OFFICIAL NOTICE OF DECISION

CITY OF ALBUQUERQUE
PLANNING DEPARTMENT
DEVELOPMENT REVIEW BOARD

Project# 1009164
12DRB-70070 ELECTRICAL LINE LOCATION VARIANCE

PNM request(s) the referenced/above action(s) for an OVERHEAD DISTRIBUTION LINE between **Innovation Substation 13 Feeder and Four Hill Substation 12**, located at JUAN TABO BLVD SE and MONACHOS RD SE south of the TIJERA ARROYO. (M-21 & 22)

**APPENDIX C: OVERHEAD**

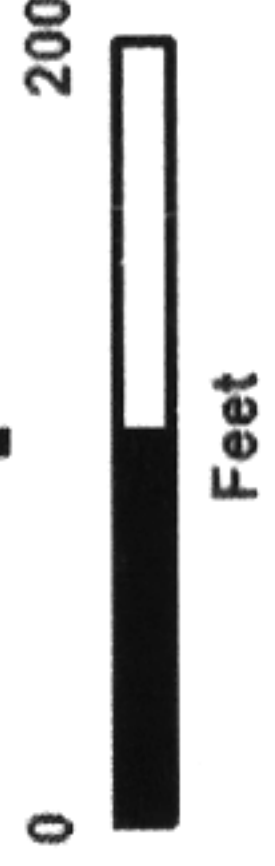
1. The location of the fourth pole may be adjusted from as shown in Appendix C to allow for the transition to go underground beneath Juan Tabo Blvd SE.
2. Appendix D shall be revised to reflect the partial approval for the western portion of the variance request.
